Ribble Valley Borough Council
Council Offices
Church Walk,
Clitheroe
Lancashire
BB7 2RA

Phone: 0300 123 6780
Email: Kathryn.Walsh@lancashire.gov.uk
Your ref: 3/2023/0814
Our ref: 3/2023/0620/HDC/KW
Date: 06 November 2023

Location: Springwood Whalley Road Hurst Green BB7 2NP
Proposal: Proposed single-storey extension to rear and single-storey extension to side. Conversion of existing barn into ancillary living accommodation and creation of rear balcony. Extension of existing garage to incorporate additional parking bay.
Grid Ref: 370307, 439117

Project Name	Project No.	Stage
Springwood	175.23	Planning Submission
Proposed Site Plan - Ground Floor	Scale	1:100 @ A1
09	Date	September 2023
Rev B	Drawn	RH

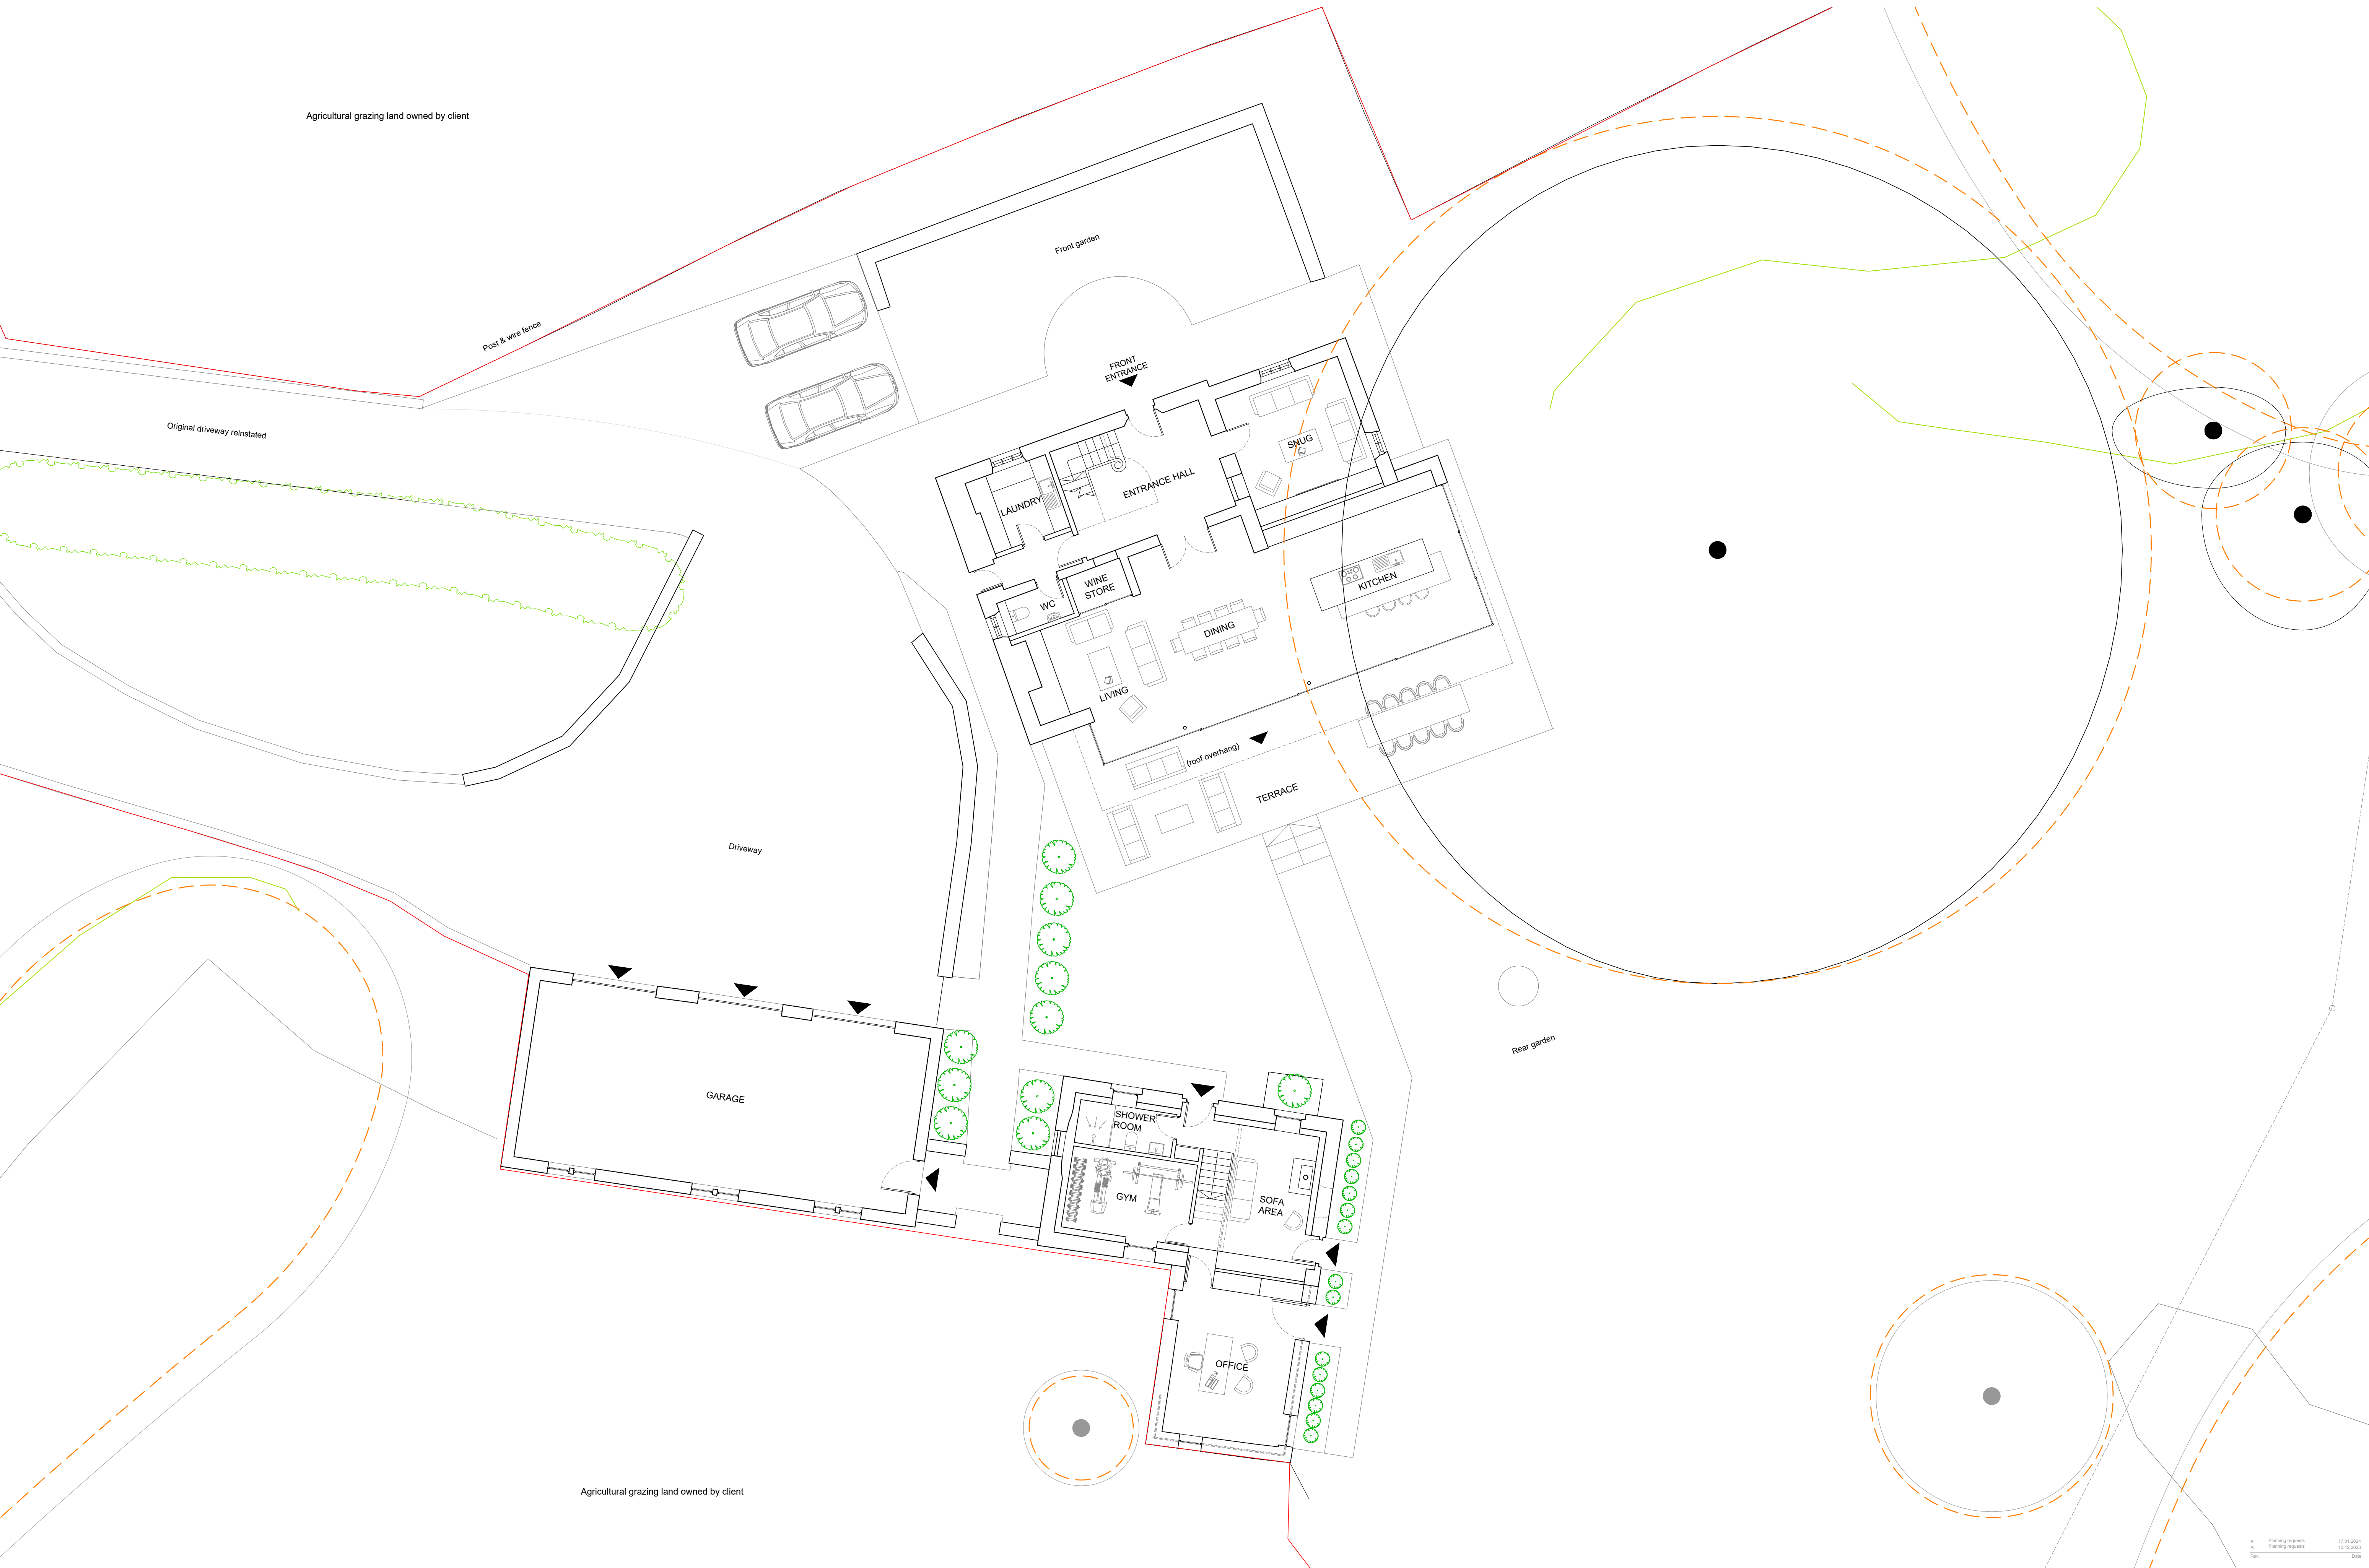
The proposed extension to the garage will allow for 3 off street parking spaces given the internal dimensions meeting the LHA guidance which is at least 6m long and 12m wide for a tripe garage. The driveway will allow vehicles to turn within the site ensure that vehicles can enter and exit the site in a forward gear.

Additionally, due to the nature of the application, it is expected that a charging point for electric vehicles shall be included within the development to promote sustainable modes of transport. This shall be fitted in line with the DfT guidance regarding Electric Vehicle Charging in Residential and Non-residential buildings, which states charge points must have a minimum power rating output of 7kW and be fitted with a universal socket that can charge all types of electric vehicles.

1. The parking and manoeuvring areas shall thereafter always remain available for parking and manoeuvring of vehicles associated with the dwelling and subsequently maintained in good working order at all times thereafter for the lifetime of the development.
